DEVELOPMENT REVIEW BOARD
SUPPLEMENTAL SUBMITTAL

PROJECT NO. PR-2020-004284

Application No. PS-2020-0076

**RE: MAJOR SUBDIVISION PRELIMINARY PLAT APPROVAL
1100 RIO GRANDE BLVD NW ALBUQUERQUE, NM 87104
TRACTS 230-A, 230-B, 230-C, 231-A-1, 231-A-2, 231-B-1, 231-B-2, 231-B-3,
234-A MRGCD MAP NO. 35 AND TRACT A, LANDS OF HARRY GARCIA
ZONE ATLAS PAGE: H-13-Z.
RESPONSE TO COMMENTS**

Plat of
Tracts 1, 2, 3, 4 & 5
Rio Grande Crossing West
 Town of Albuquerque Grant, Projected
 Section 7, Township 10 North, Range 3 East, N.M.P.M.
 City of Albuquerque, Bernalillo County, New Mexico
 August 2021

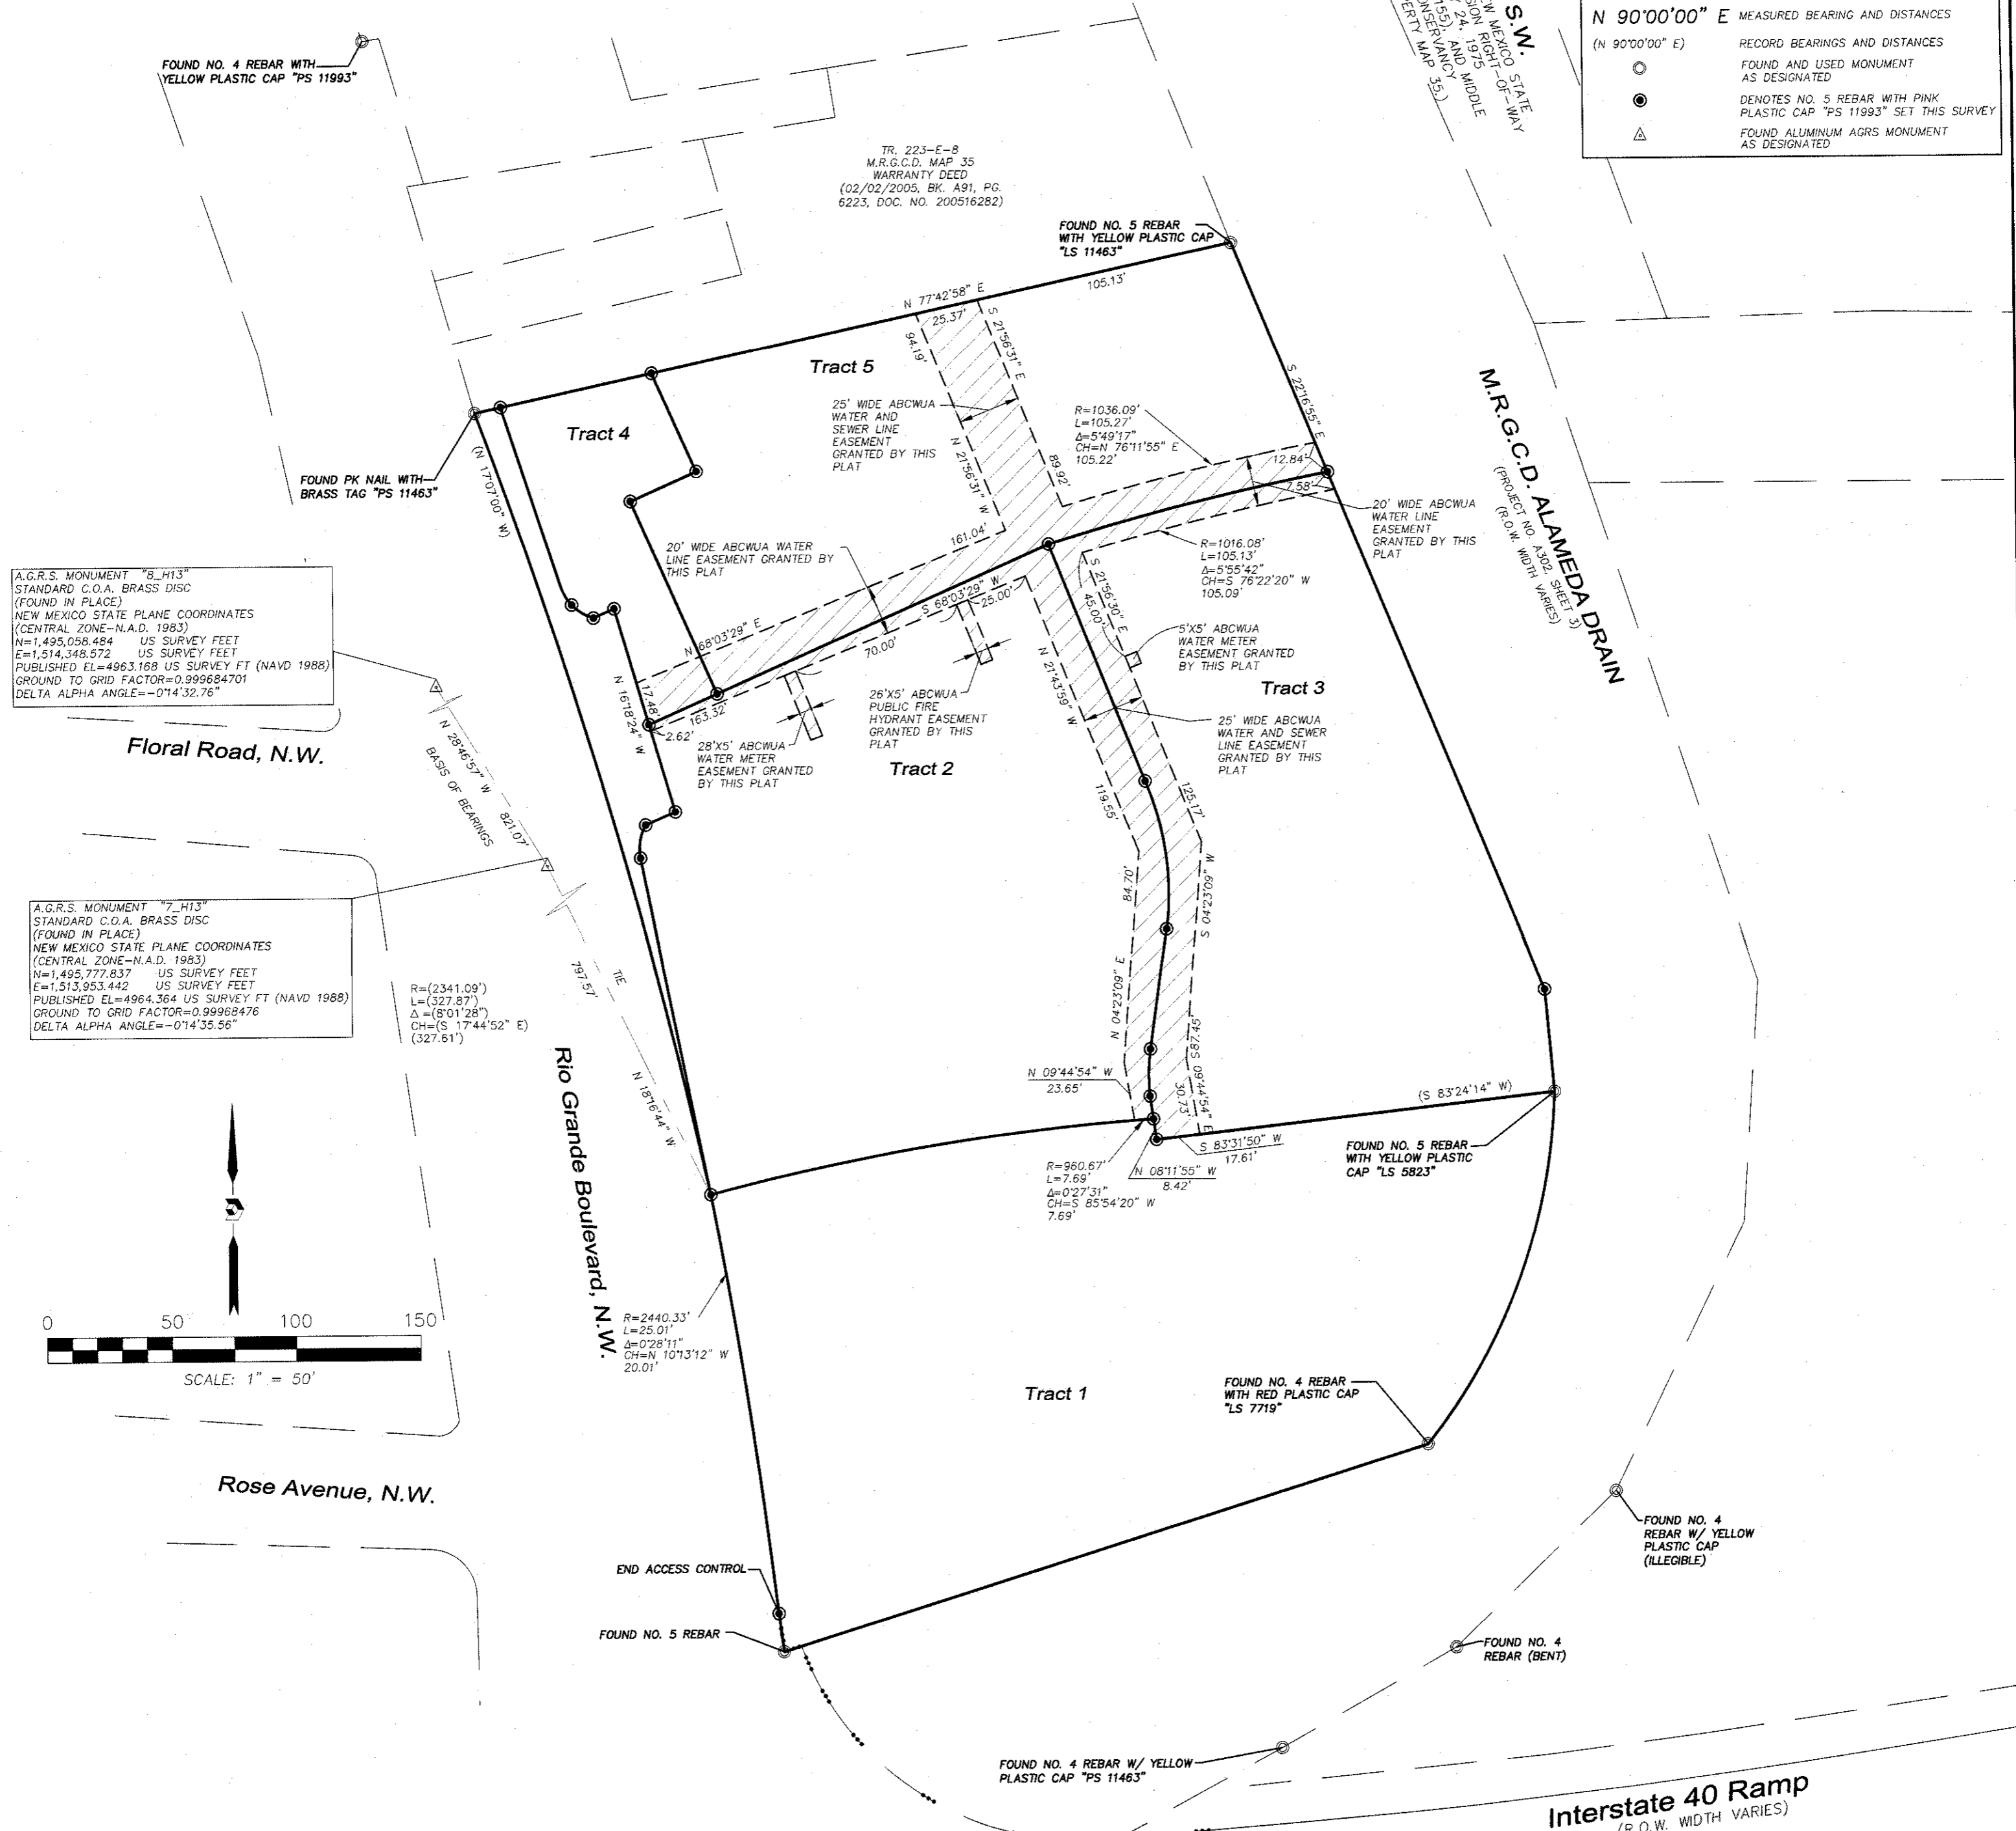
- a. Please add the following note:
 - i. "Existing public water and/or sanitary sewer infrastructure may not be constructed or sized to adequately serve potential future development. Improvement or upsizing of existing public infrastructure may be required as a condition of future development approval."

- b. The proposed hydrant for the future credit union can benefit multiple parcels and would be best utilized as a public hydrant. Please generate additional public waterline easement as necessary to accomplish this.

- c. The proposed 25 foot public water and public sewer easement on Tract 1 does not coincide with any mains on the latest utility plan. Please confirm if this easement is necessary.

Response: Acknowledged, updated plat attached below.

Response: Acknowledged, updated plat attached below.

Response: ABCWUA easement on Tract 1 to be platted in the event that additional water line extensions are necessary in the future.
